El Paso County
Planning & Community Development
Planning Checklist

Parcel Number: 7111400007; 7111404111

Zone	Name
<u>PUD</u>	<u>PUDSP164</u>

CONCEPTUAL
LAYOUT
04/15/21

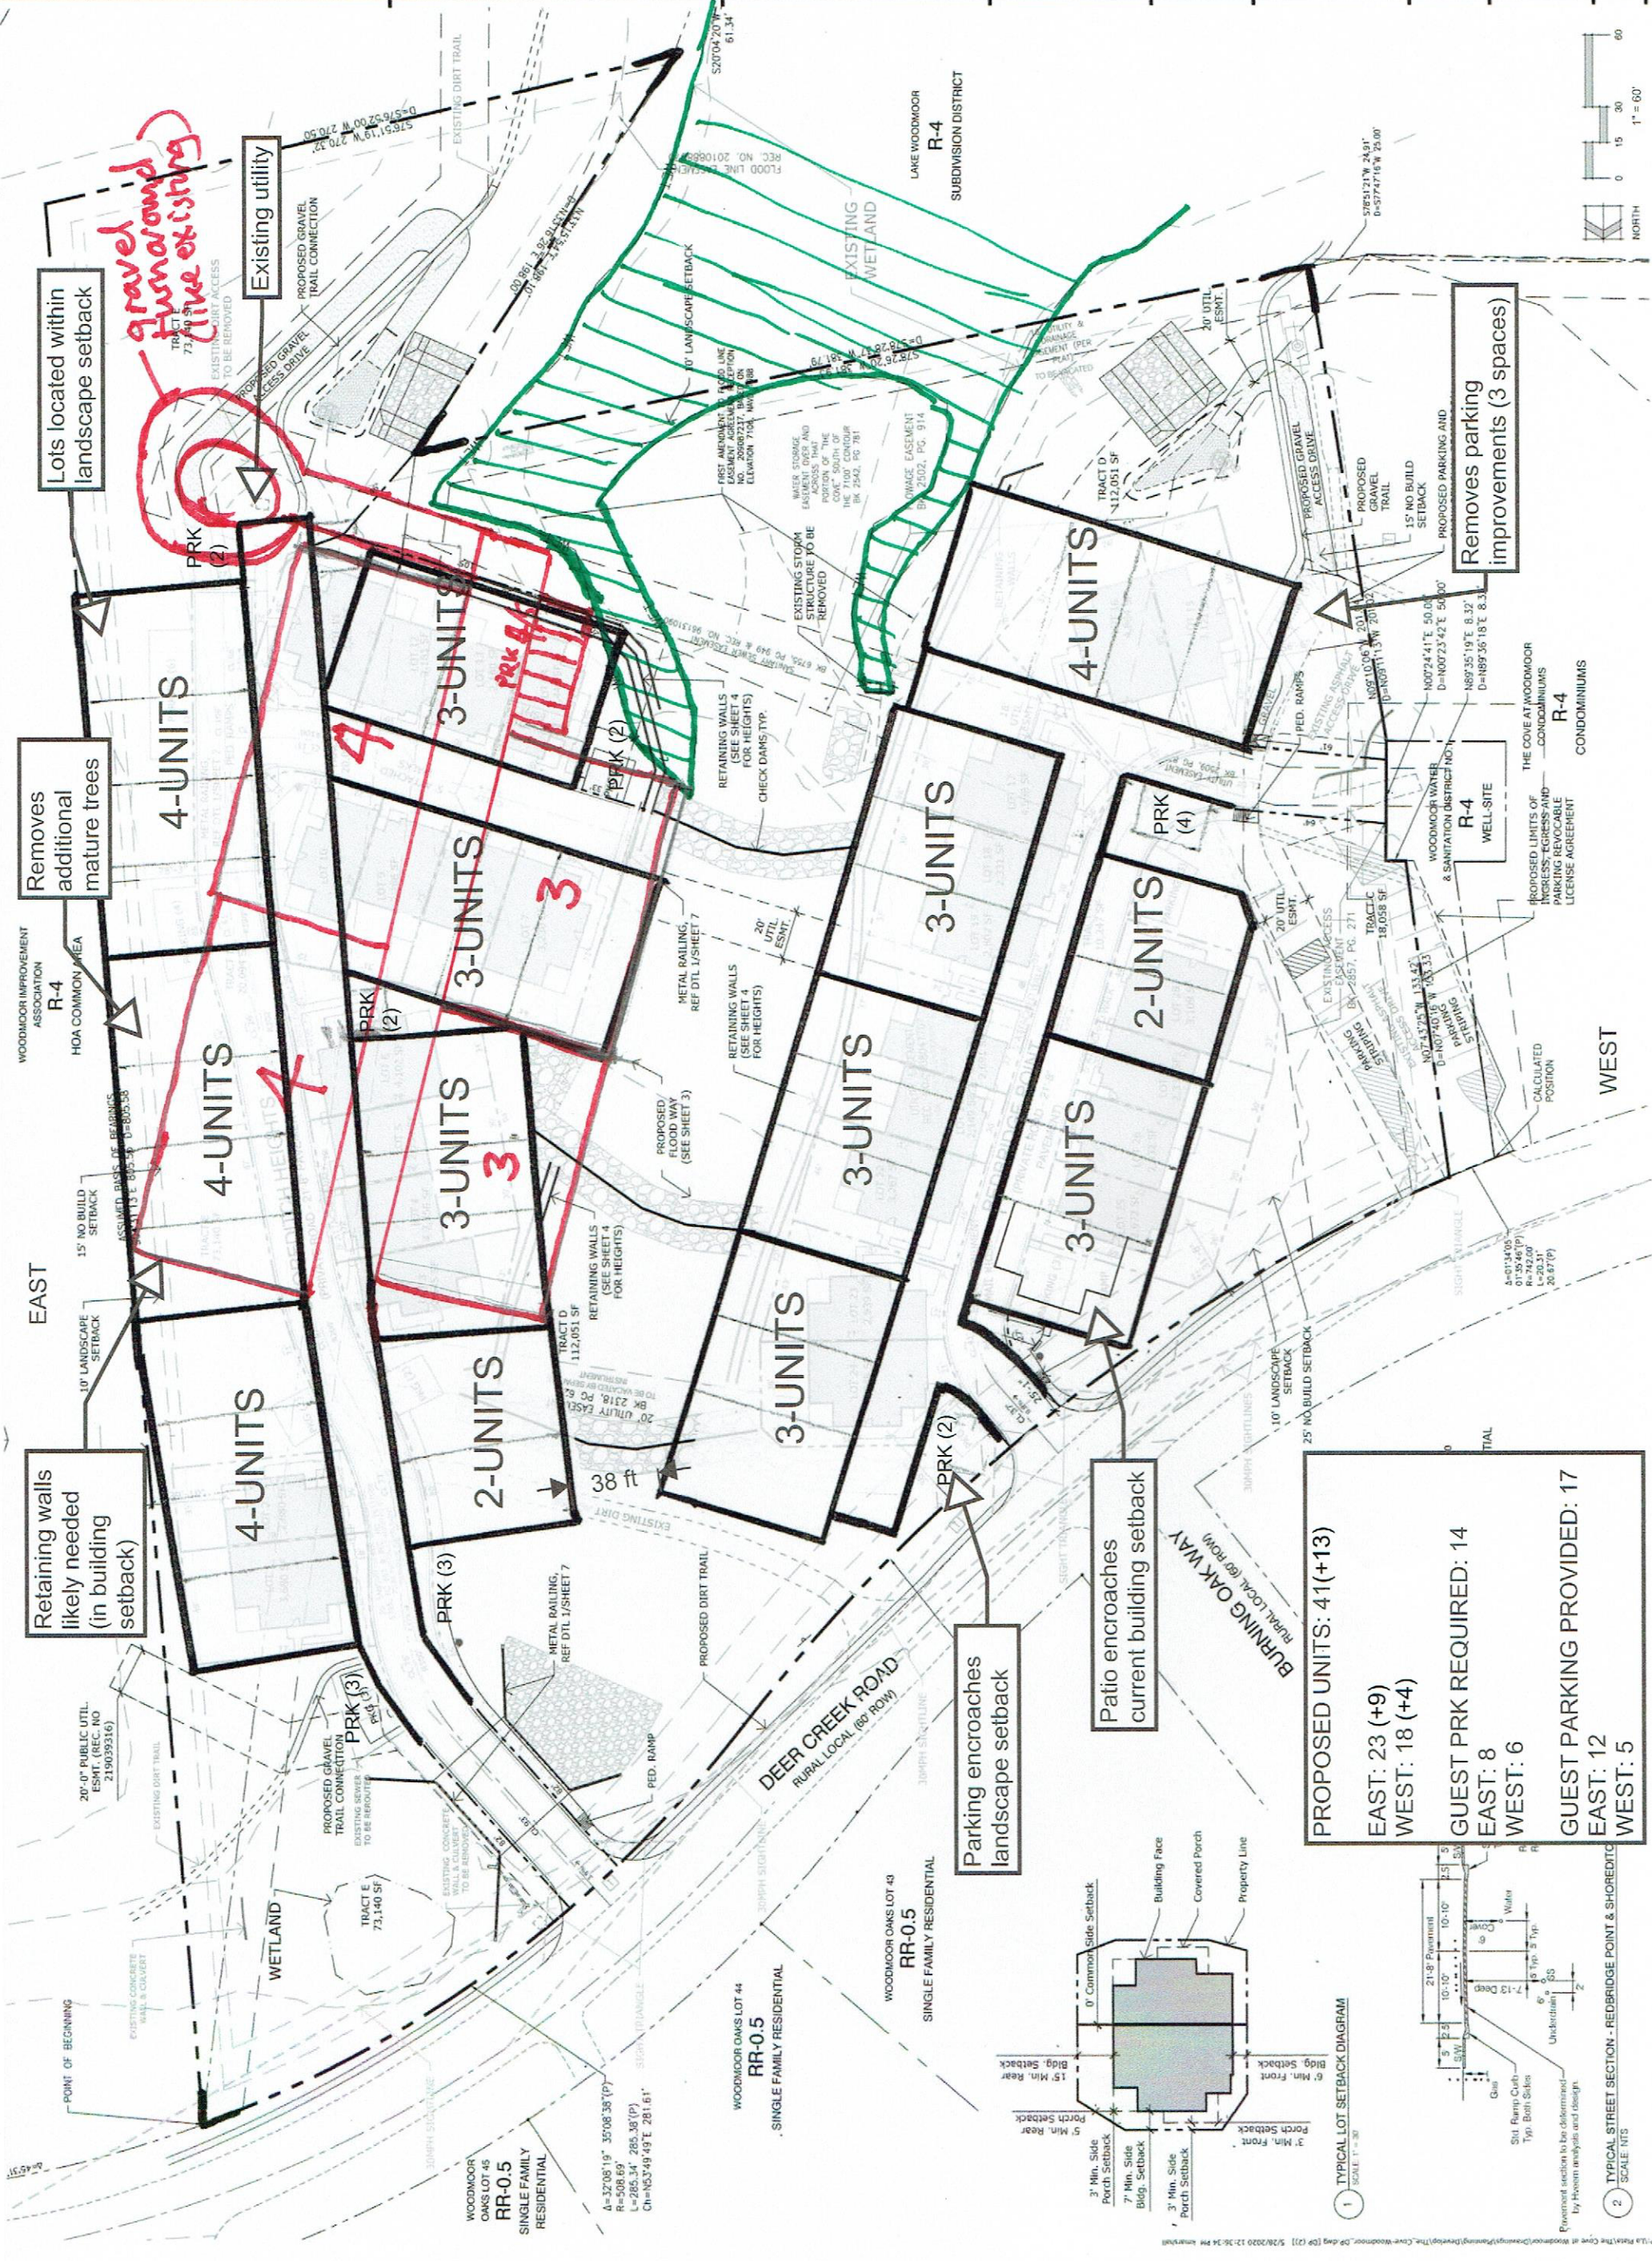
Existing PUD: 6 ft front setback, 3 ft porch; 7 ft side setback, 3 ft porch, 0 ft common; 15 ft rear setback, 5 ft porch

3.87 DU/ac -> 5.6 DU/ac

How will landscaping be impacted by layout change? East landscape buffer? Units encroach road buffer
